Final Drainage Report

Ellicott School Addition - 2 Buildings

Project No. 61183

September 1, 2022

MVE PROJECT 61183
MVE DRAWING DRAIN-PP-I

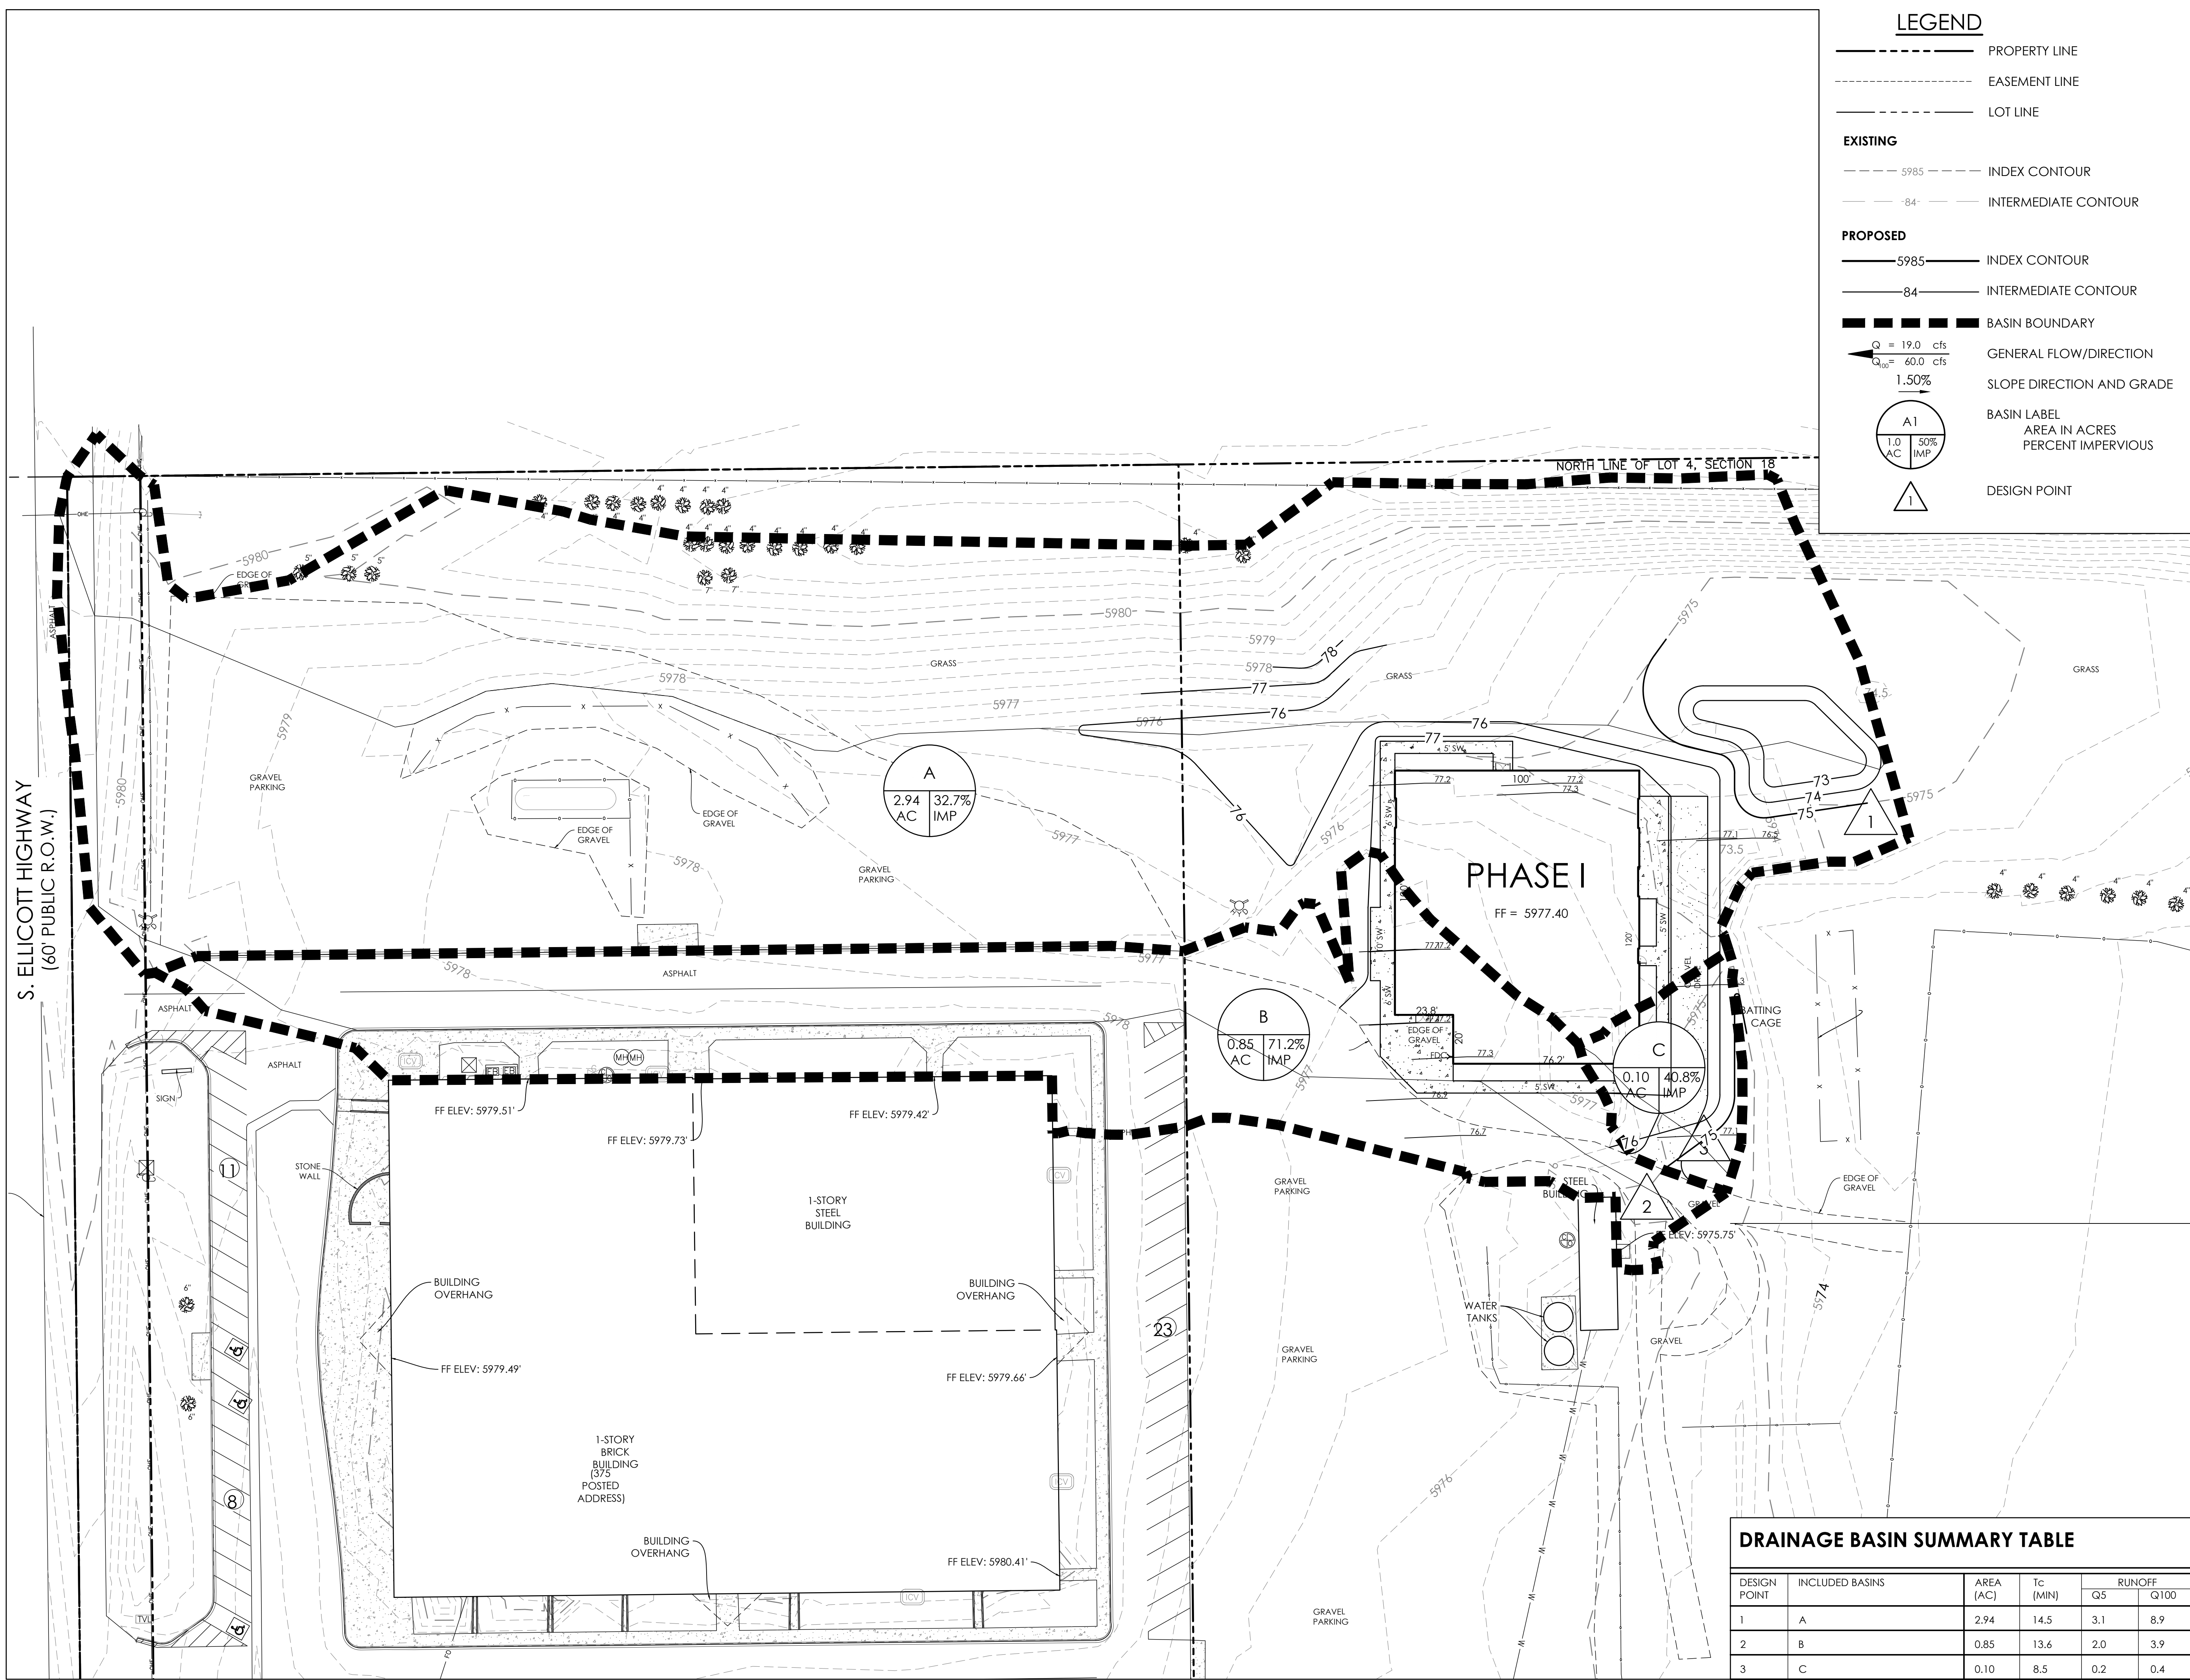
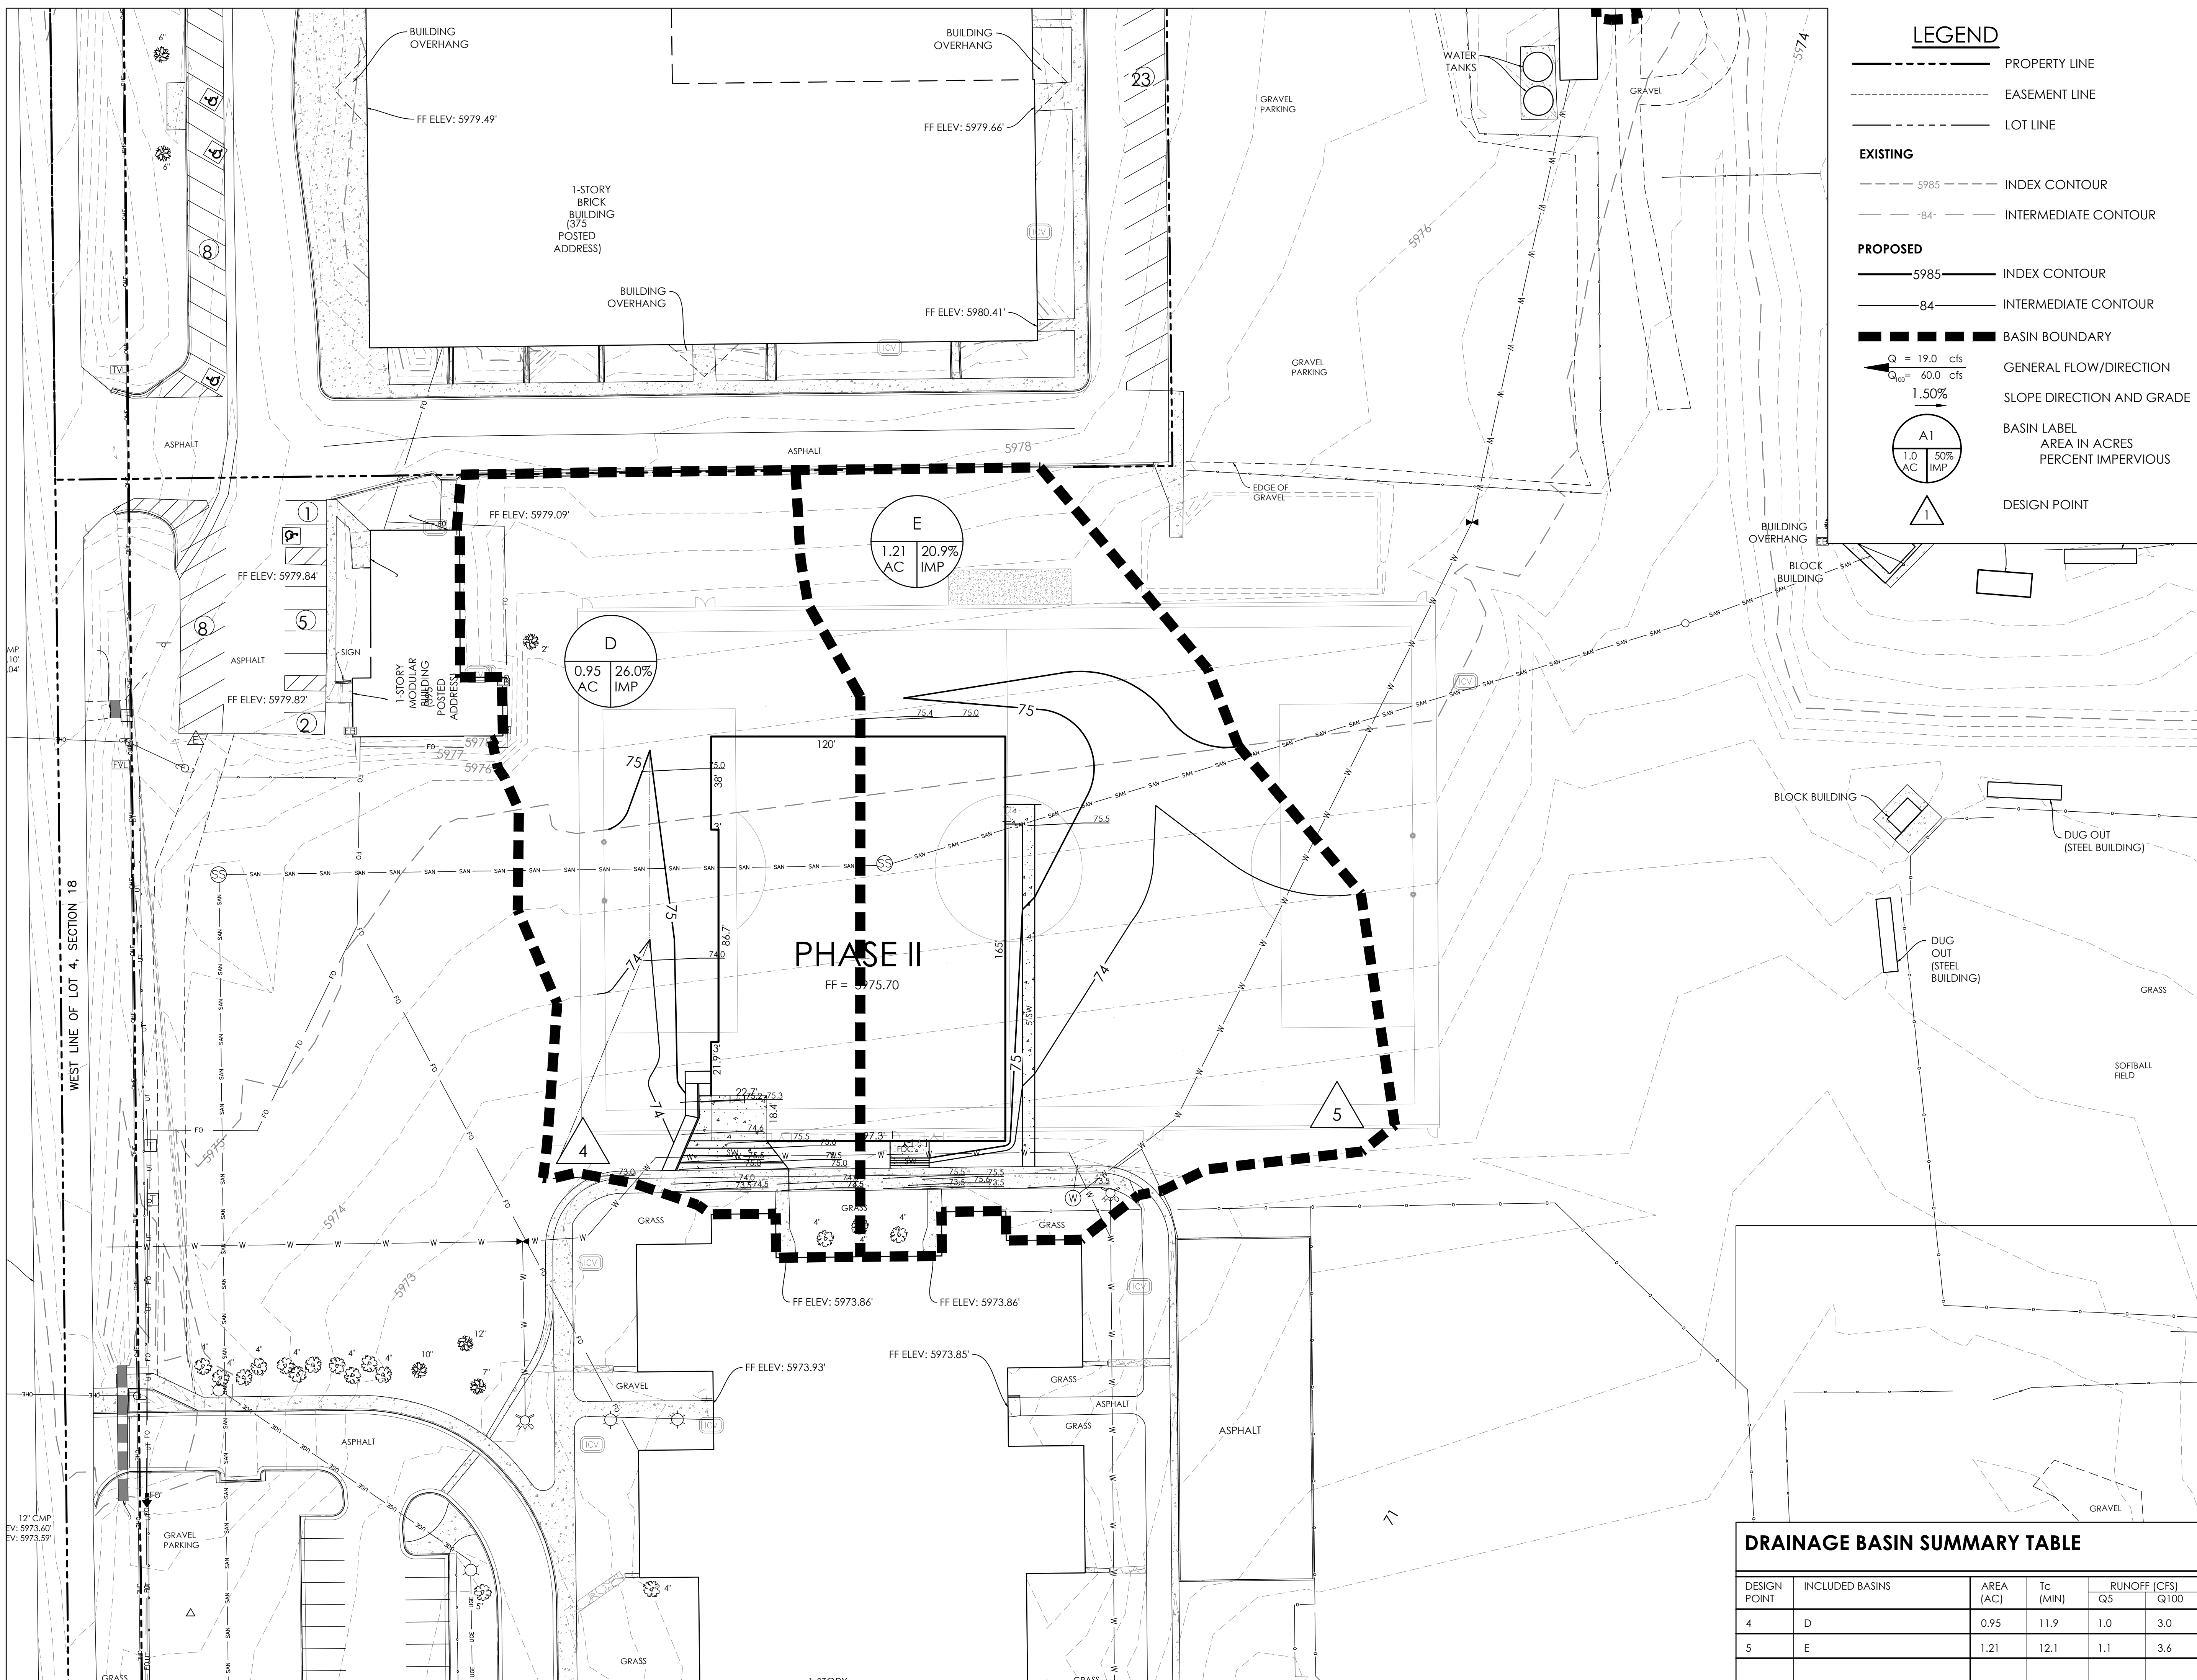
See comments on drainage maps
